Rezoning Transportation Analysis
Petition Number: Insert Zoning Petition #2021-257
General Location Identifier: 11306113

Revision Log:

Date	Description
04-18-2022	First Review (KP)
05-24-2022	Second Review (KP)
06-23-2022	Third Review (KP)

Conceptual Site Plan

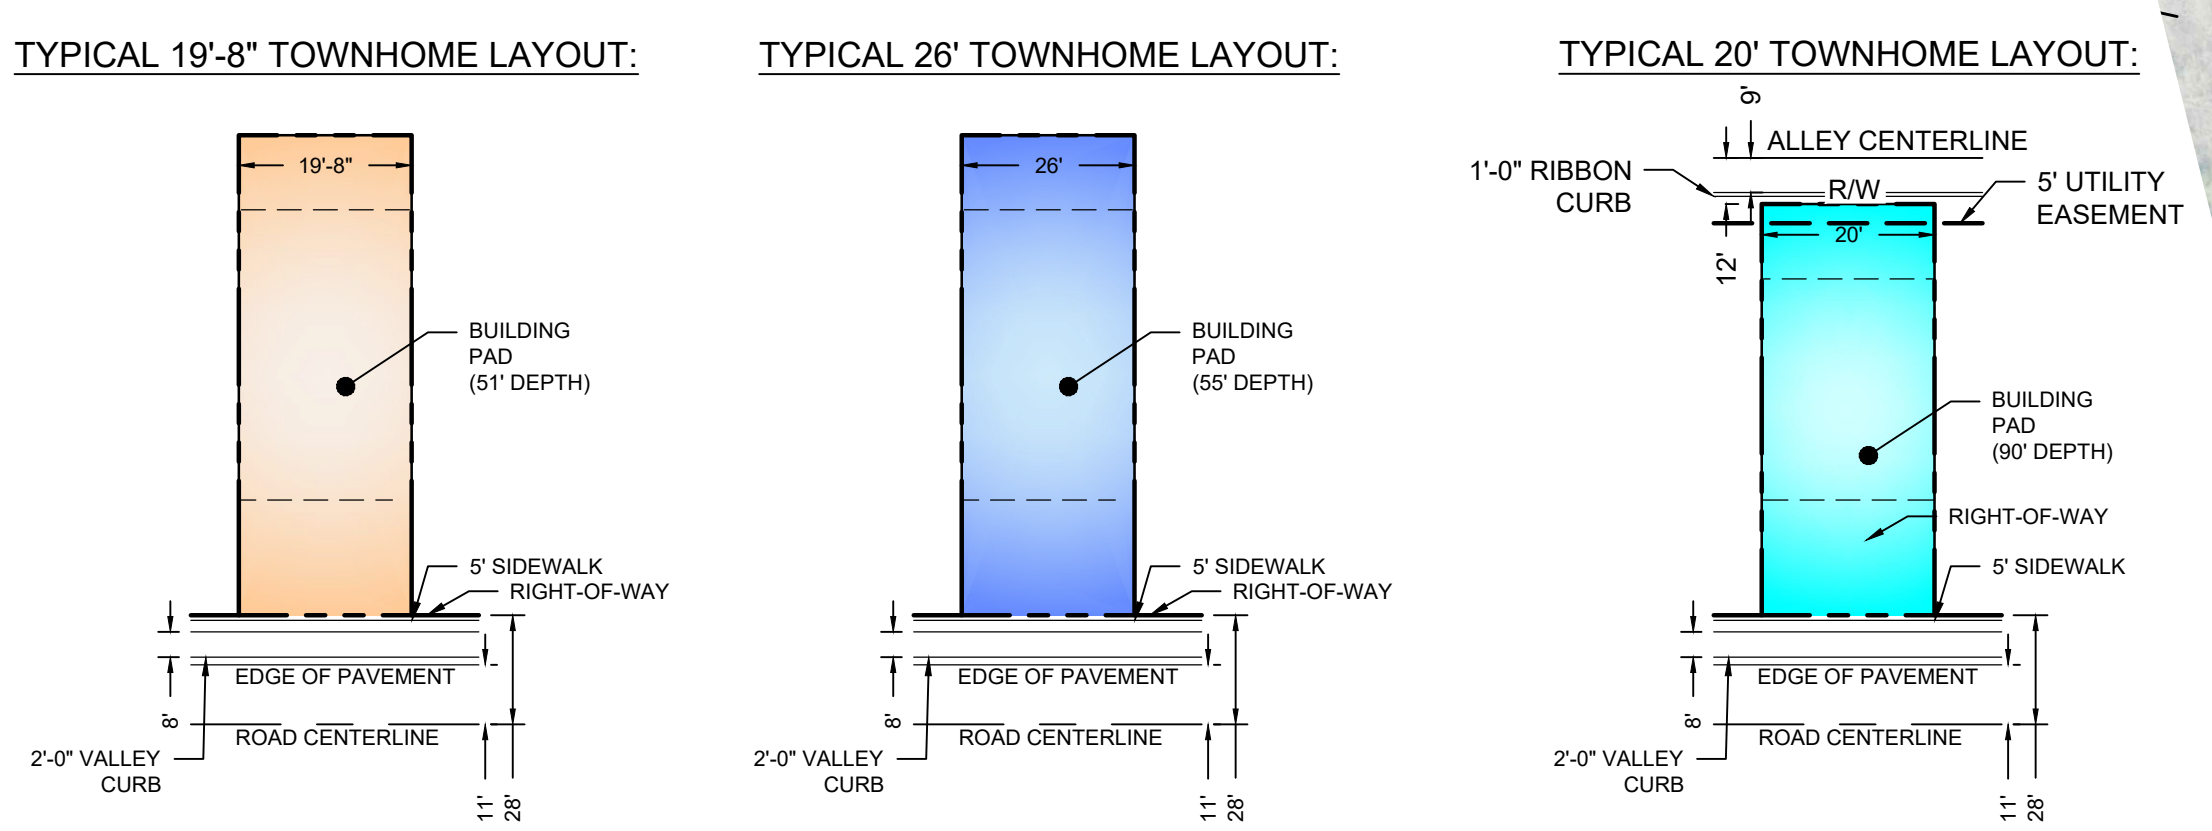
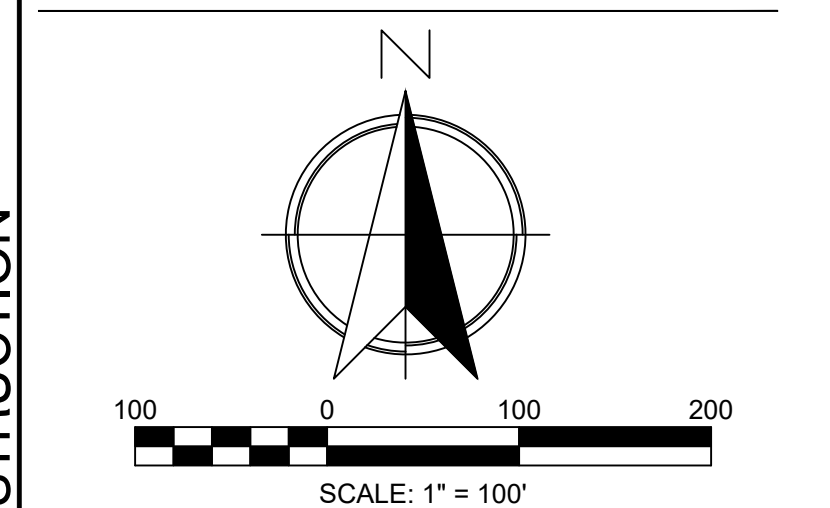
Label and dimension the curb and gutter from the centerline for each road on the site plan.

Update to Comment as a result of the 06-13-2022 Site Plan: Phasing of improvement at intersection of Amos Smith and Access B needs to be verified by NCDOT, and documentation of NCDOT approval needs to be provided to CDOT.

Not in approved TIS.
Approved by NCDOT?

Revise the site plan and conditional notes by incorporating the suggested roadway improvements from the approved TIS.

**REZONING
NOTES**

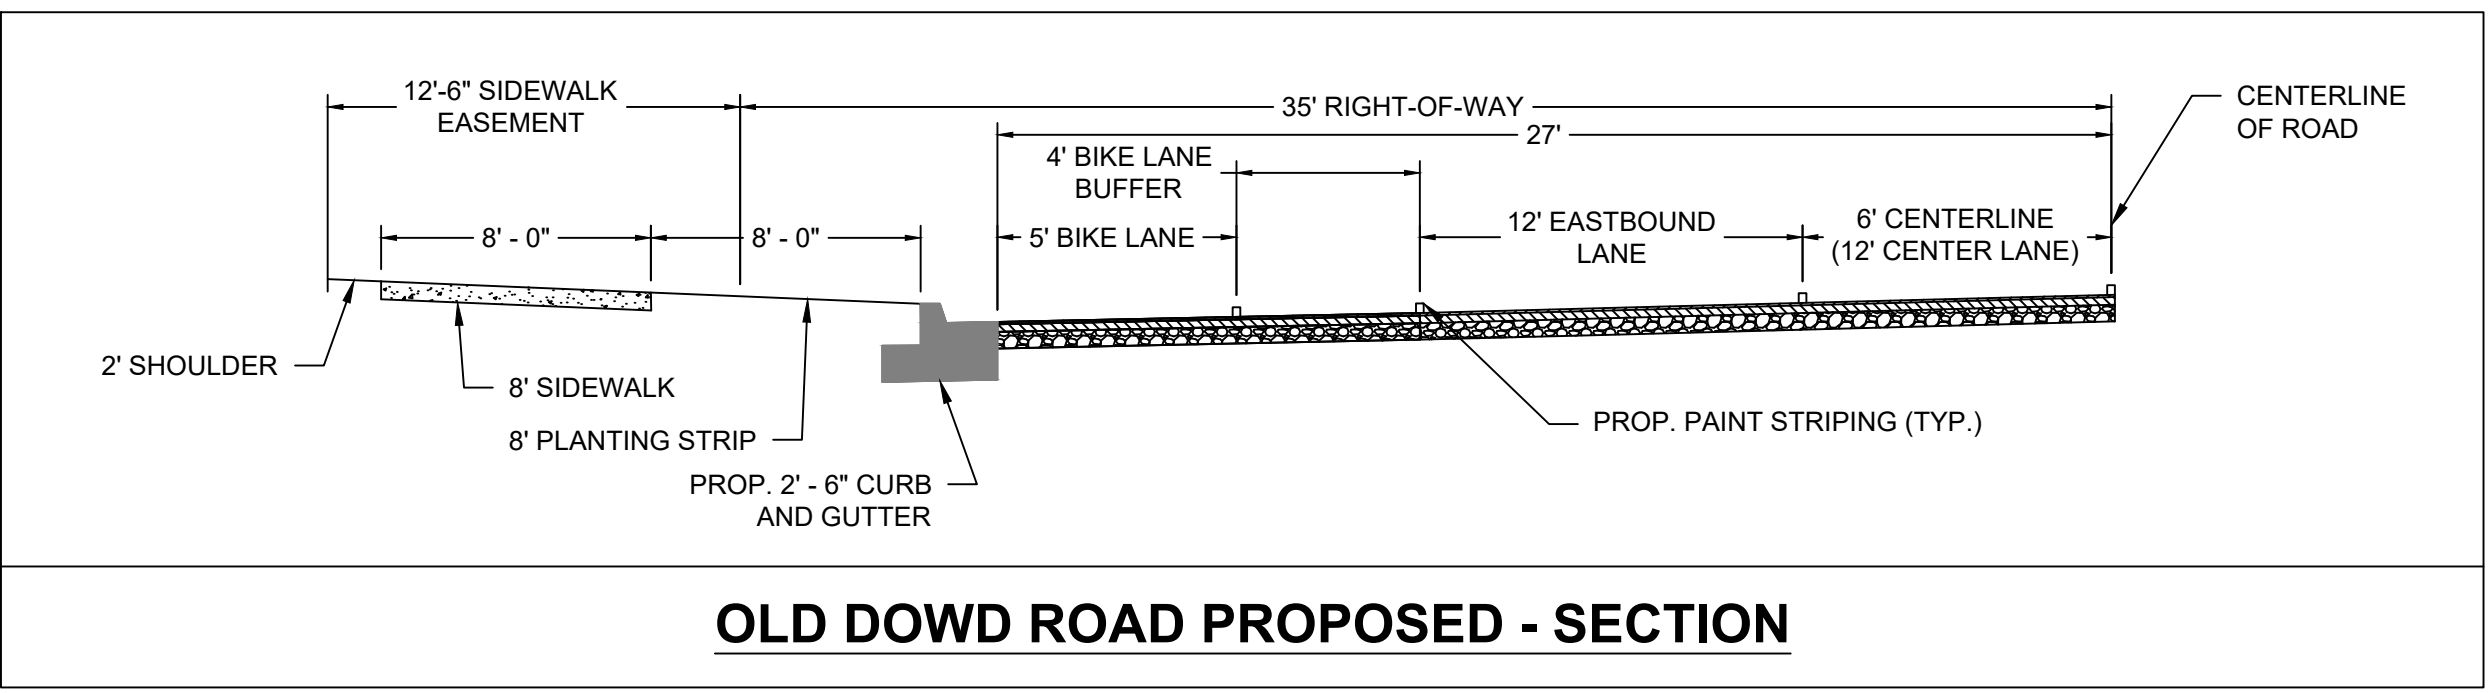
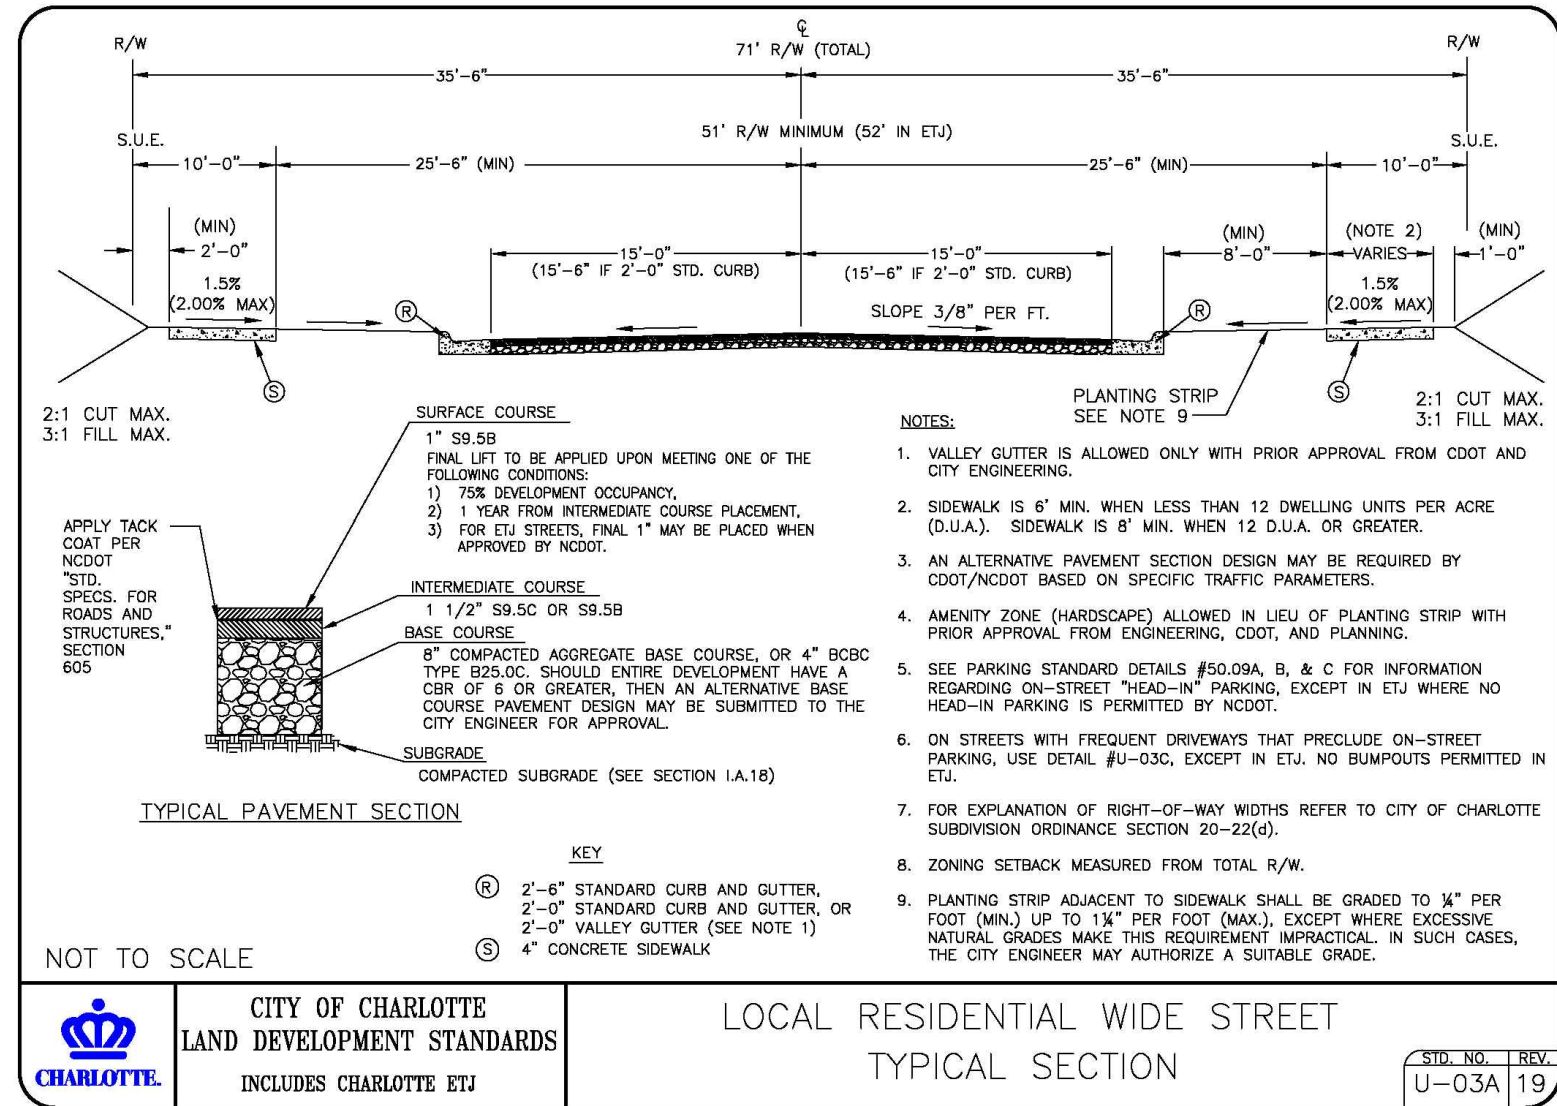
- 8. A site plan note specifying that all transportation improvements will be approved and constructed before the site's first building certificate of occupancy is issued as needed. The petitioner may phase transportation improvements if said improvements and phasing are explicitly described in site plan notes.
Update to Comment from 05-18-2022 Site Plan: Confirm with NCDOT that tying the roadway improvements to 100th certificate of occupancy is acceptable. Provide documentation to CDOT of NCDOT approval.
